Hu Yu Residence

Addition and Remodel

SHEET NUMBER:
A1.01

Summary of Comments on 2201-224-SUB1-PLANS_review.pdf

**Foundation & Main Floor Plan**  
Scale: 1/4" = 1'-0"

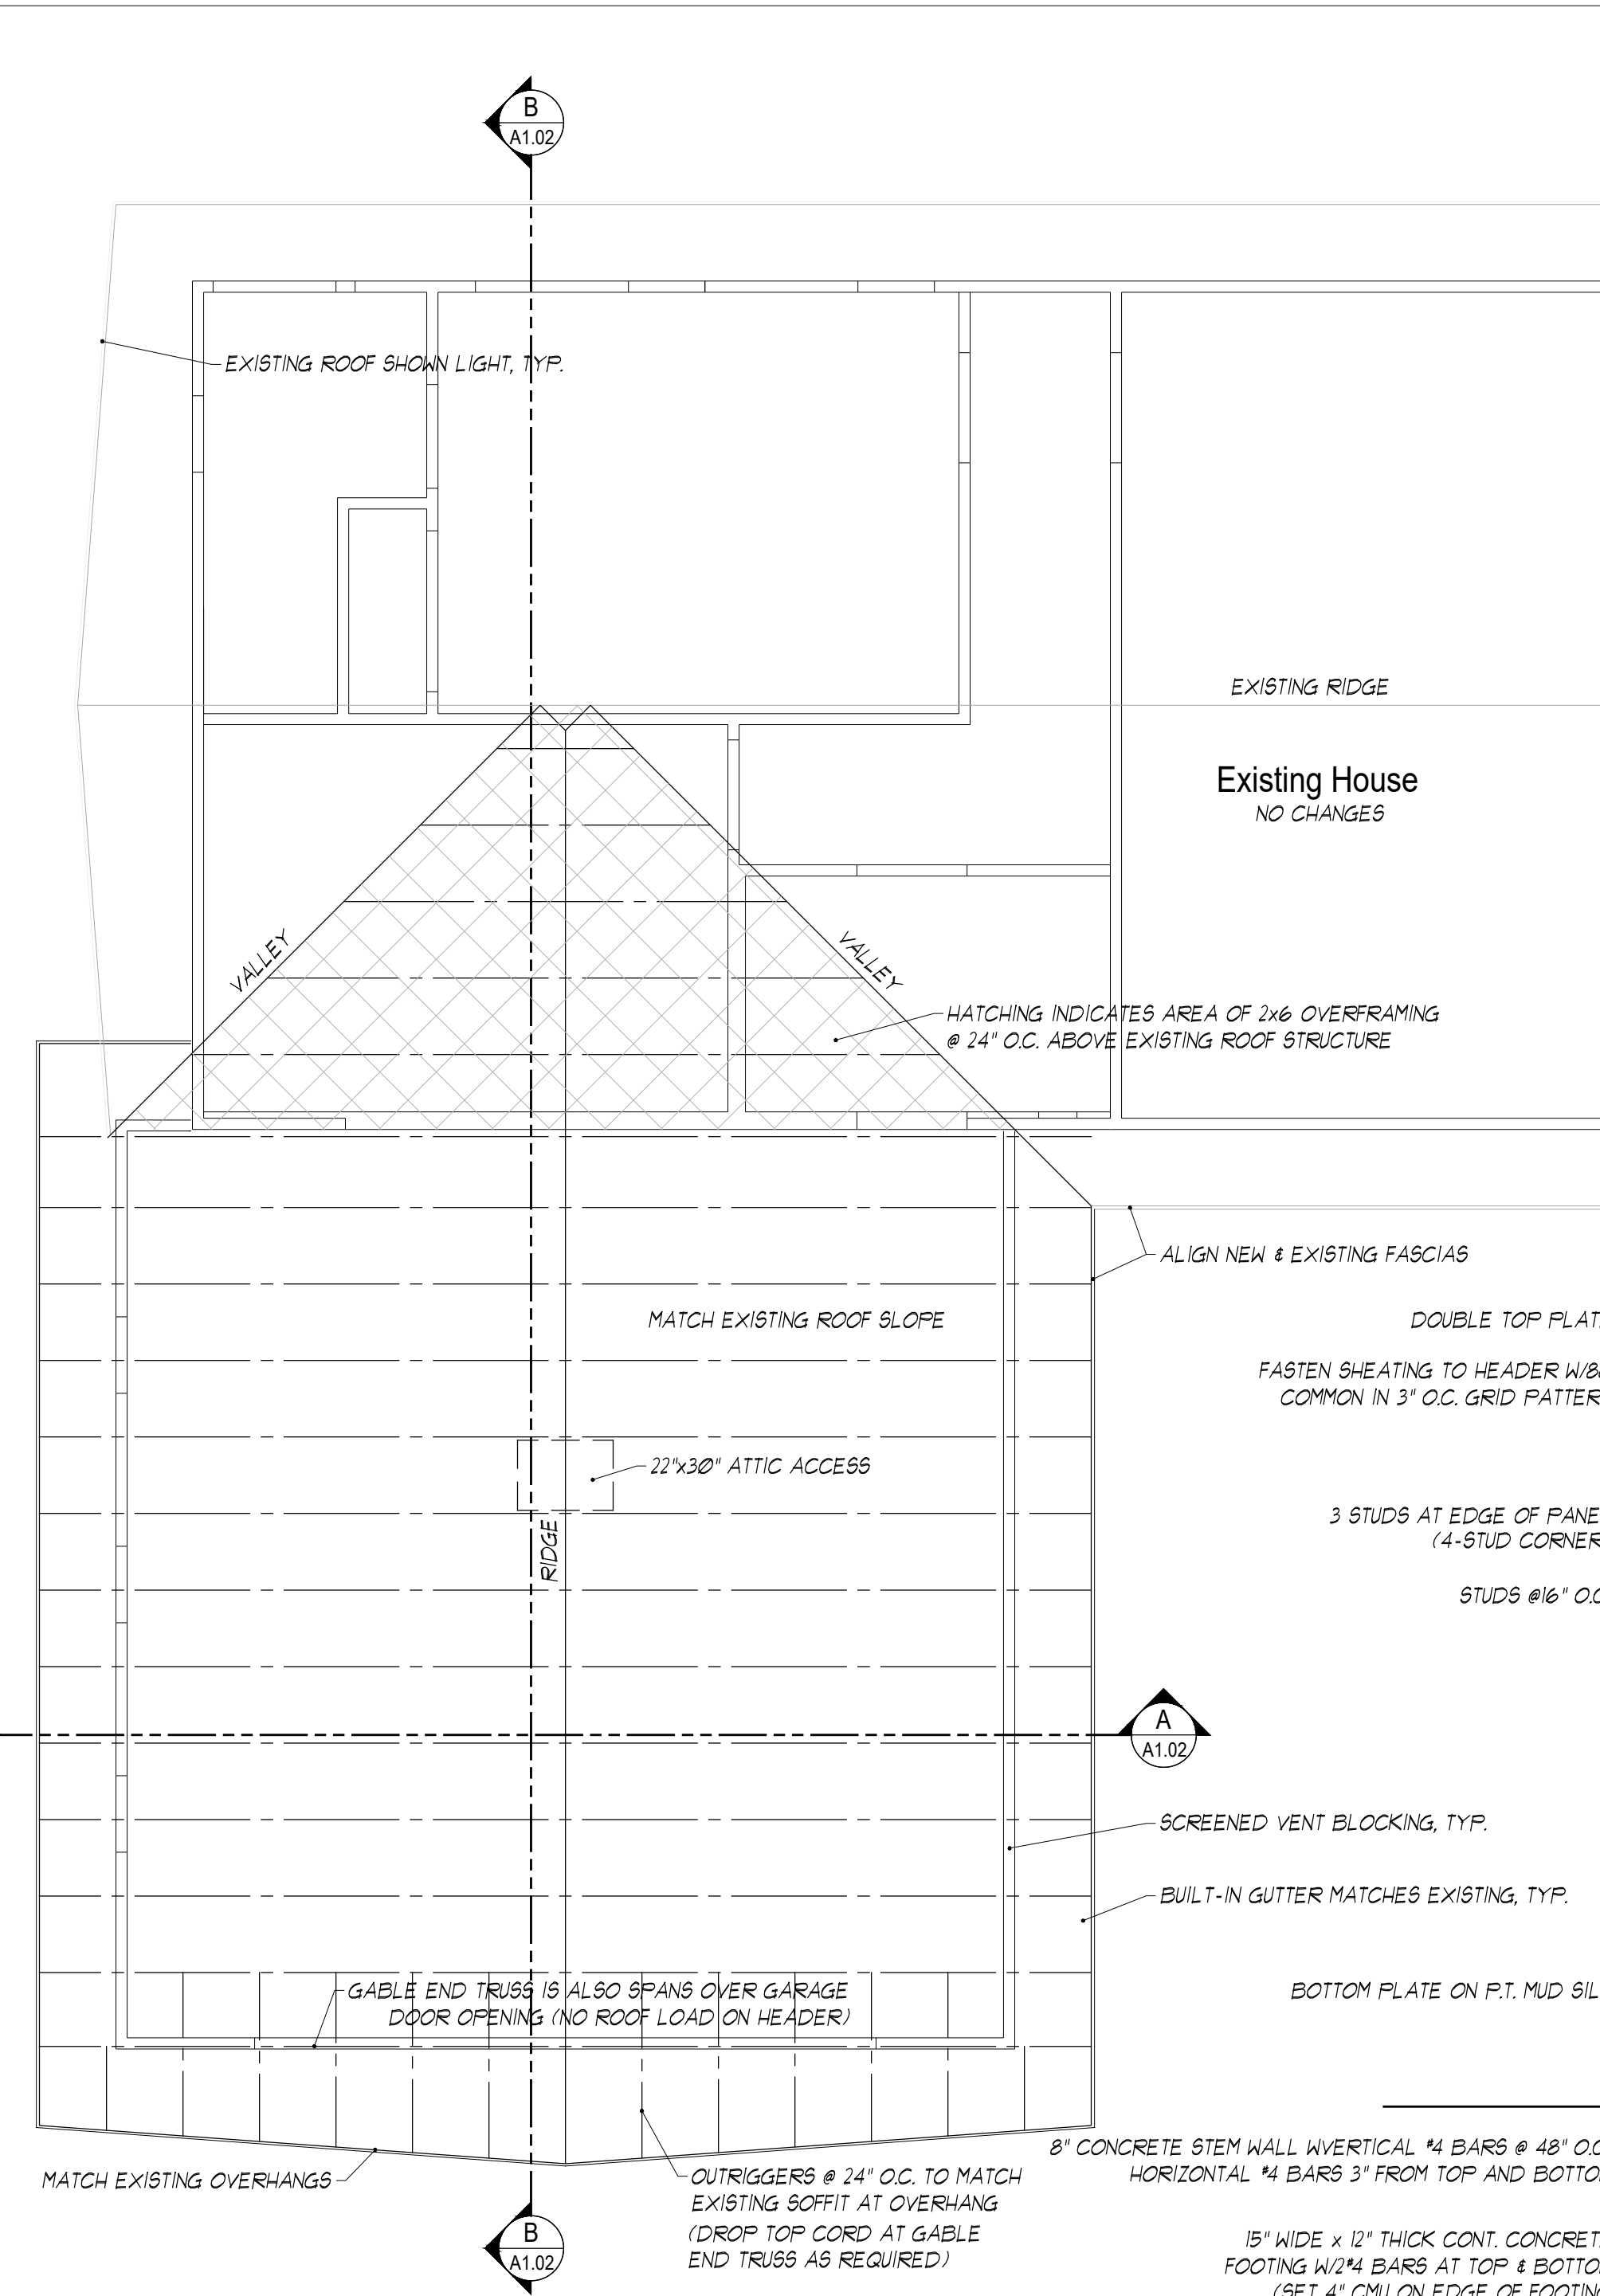
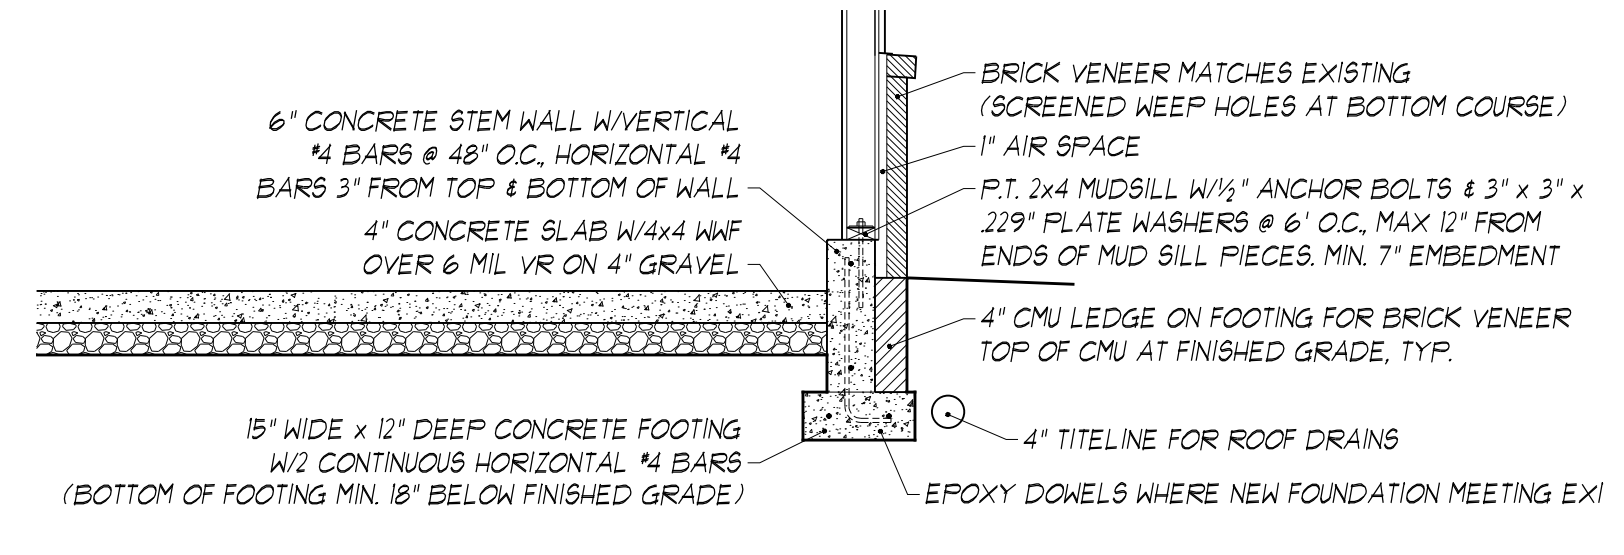
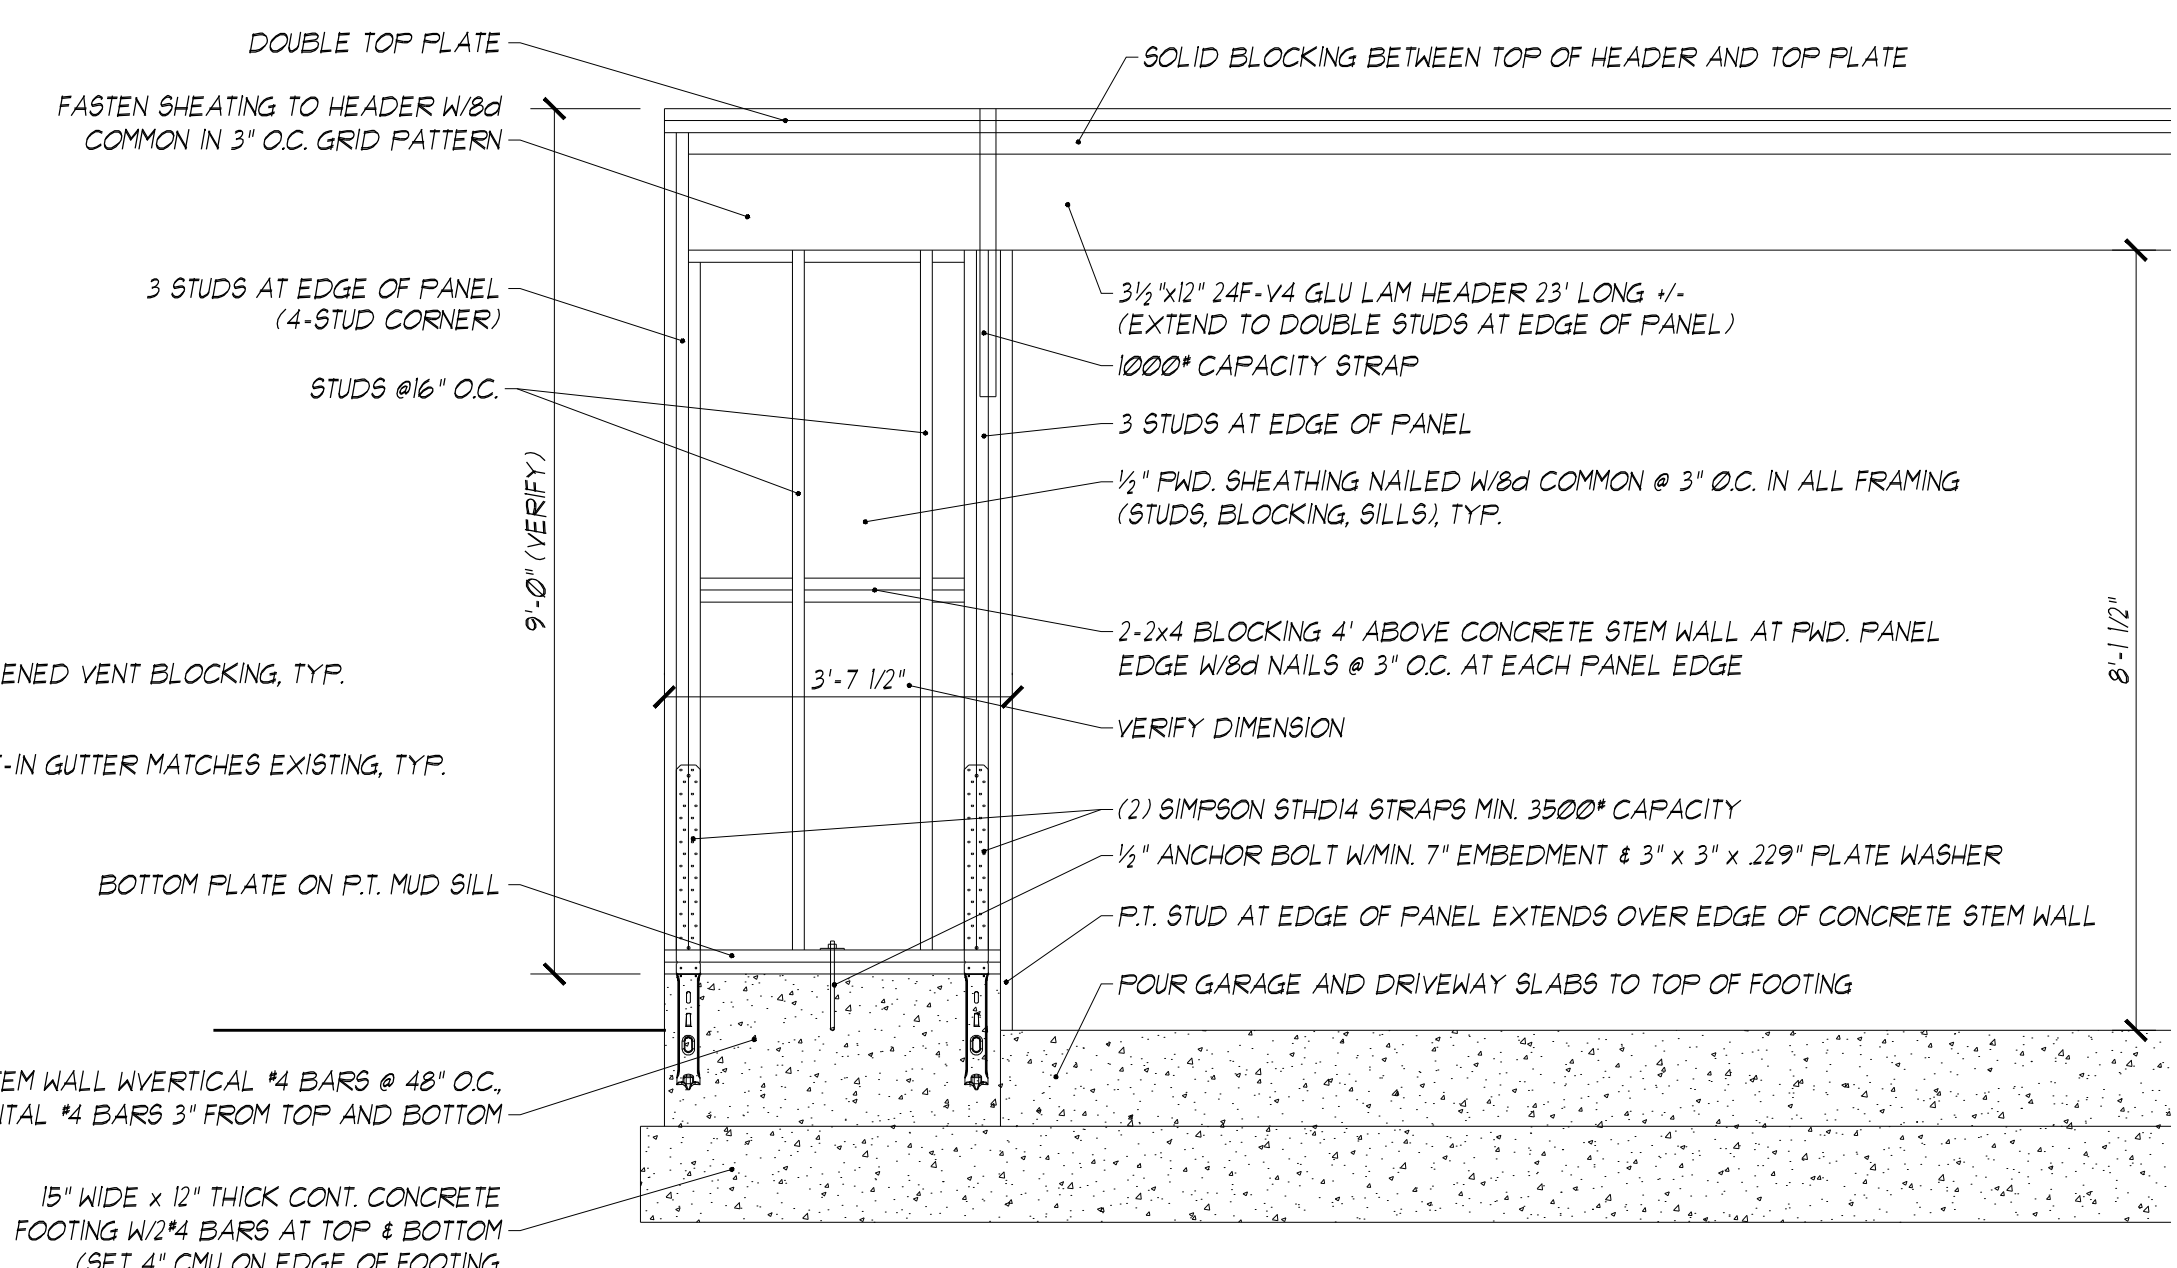
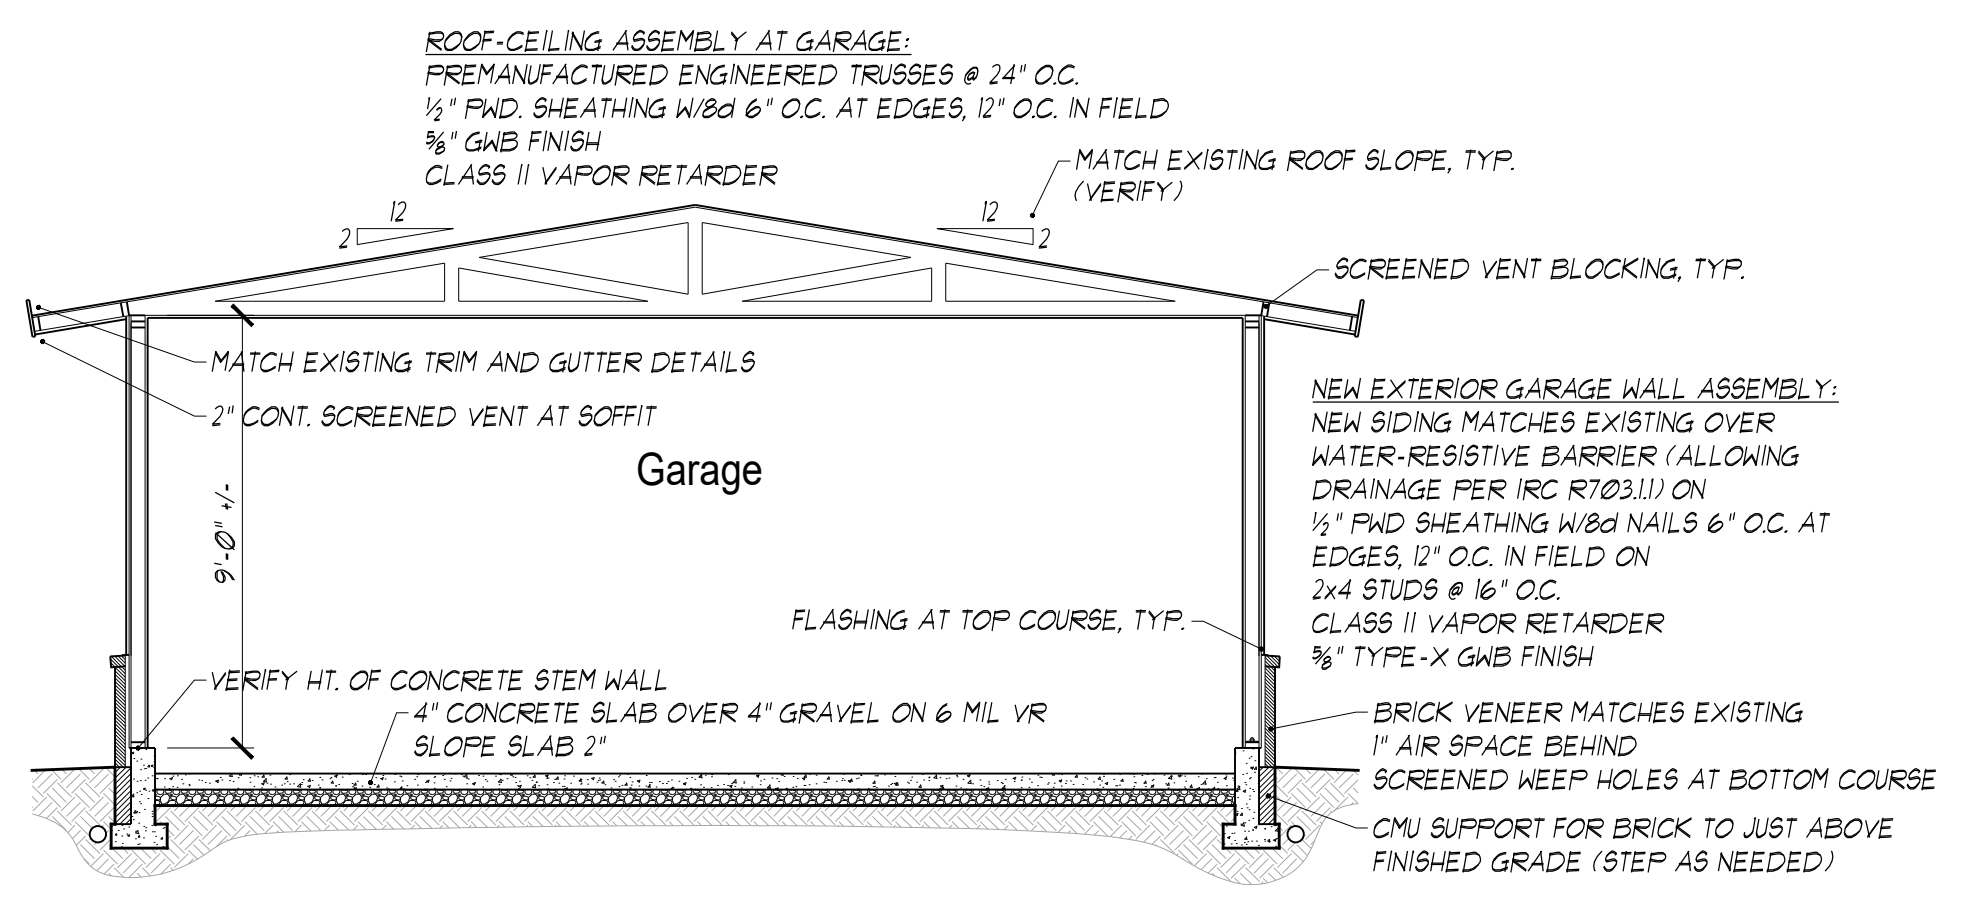
<p>Number: 1</p>	<p>Author: Building Plan Review (jacob.halverson@mercerisland.gov)</p>	<p>Subject: Sticky Note</p>	<p>Date: 6/22/2022 10:11:47</p>
<p> Provide foundation plan and locate all new and existing (presumed) extents/depths and foundations.</p>			
 <p>Number: 2</p>	<p>Author: Building Plan Review (jacob.halverson@mercerisland.gov)</p>	<p>Subject: Sticky Note</p>	<p>Date: 6/22/2022 10:07:18</p>
<p> Room as detailed (Den) resembles a sleeping room, provide this window as egress.</p>			
 <p>Number: 3</p>	<p>Author: Building Plan Review (jacob.halverson@mercerisland.gov)</p>	<p>Subject: Sticky Note</p>	<p>Date: 6/22/2022 10:06:36</p>
<p> Provide an additional smoke detector in this room.</p>			
 <p>Number: 4</p>	<p>Author: Building Plan Review (jacob.halverson@mercerisland.gov)</p>	<p>Subject: Sticky Note</p>	<p>Date: 6/22/2022 10:05:29</p>
<p> Provide note that provides compliance per: R302.5: Openings and penetrations through the walls or ceilings separating the dwelling from the garage shall be in accordance with Sections R302.5.1 through R302.5.3.</p>

<p>Number: 5</p>	<p>Author: Building Plan Review (jacob.halverson@mercerisland.gov)</p>	<p>Subject: Sticky Note</p>	<p>Date: 6/22/2022 10:03:39</p>
<p> Provide all separation requirements per IRC R302.6 on plan or building section for clarity for dwelling/garage fire separation. Garage separation requirements include 5/8" type X between garage and habitable space above, 1/2" between garage and habitable space on garage side of walls, and a 20 min rated or solid core entry door with a self-closing device.</p>			
 <p>Number: 6</p>	<p>Author: Building Plan Review (jacob.halverson@mercerisland.gov)</p>	<p>Subject: Sticky Note</p>	<p>Date: 6/22/2022 10:04:29</p>
<p> dedicated mechanical space found elsewhere in the residence. Please locate major mechanical equipment.</p> <p>If Mechanical equipment appears to interfere with drive aisle and If mechanical equipment is to be in garage, show location and provide bollard/bollards or approved alternative to protect mechanical equipment in driveway per M1307.3.1. If curb provided note requirement per M1307.3 requiring 18".</p>

<p>Number: 7</p>	<p>Author: Building Plan Review (jacob.halverson@mercerisland.gov)</p>	<p>Subject: Sticky Note</p>	<p>Date: 6/22/2022 10:09:07</p>
<p> Provide attic ventilation per (R806.1) & calculations unless insulation is applied on the under-side of roof sheathing. (R806.5)</p>			
 <p>Number: 8</p>	<p>Author: Building Plan Review (jacob.halverson@mercerisland.gov)</p>	<p>Subject: Sticky Note</p>	<p>Date: 6/22/2022 10:03:02</p>
<p> Provide heat detector. R314.2.3 A heat detector or heat alarm rated for the ambient outdoor temperatures and humidity shall be installed in new garages that are attached to or located under new and existing dwellings. Heat detectors and heat alarms shall be installed in a central location and in accordance with the manufacturer's instructions.</p>			
 <p>Number: 9</p>	<p>Author: Building Plan Review (jacob.halverson@mercerisland.gov)</p>	<p>Subject: Sticky Note</p>	<p>Date: 6/22/2022 10:17:39</p>

<p> Indicate any shearwalls, provide shearwall design and schedule to resist any lateral forces garage is subject to. Provide holddown details, locations, and design if required - on foundation or framing plan.</p>			
 <p>Number: 10</p>	<p>Author: Building Plan Review (jacob.halverson@mercerisland.gov)</p>	<p>Subject: Sticky Note</p>	<p>Date: 6/22/2022 10:16:29</p>
<p> Provide a typical over framing detail of connection between existing sheathing/roof system and new proposed roof sheathing and system. Specify nailing at a minimum at connections.</p>			
 <p>Number: 11</p>	<p>Author: Building Plan Review (jacob.halverson@mercerisland.gov)</p>	<p>Subject: Sticky Note</p>	<p>Date: 6/22/2022 10:19:49</p>
<p> Provide truss to top plate detail structural detail.</p>			
 <p>Number: 12</p>	<p>Author: Building Plan Review (jacob.halverson@mercerisland.gov)</p>	<p>Subject: Sticky Note</p>	<p>Date: 6/22/2022 10:26:55</p>

<p> R301.1.3: Work done in this area affects structural. Specification and details of a new header and supports traced to foundation/ shear transfer will be required with supporting calculations. Prescriptive approach to design if conforming entirely to WSRC, and calculations for any elements which are designed per WSBC to be provided.</p> <p>If this is not done prescriptively a registered design professional will need to do design and submit calculations with a key plan.</p>			
 <p>Number: 13</p>	<p>Author: Building Plan Review (jacob.halverson@mercerisland.gov)</p>	<p>Subject: Sticky Note</p>	<p>Date: 6/22/2022 10:23:03</p>
<p> Provide this structural detail, at proposed new flooring to existing foundation to floor. I.e. Is this is ledger condition now?</p>
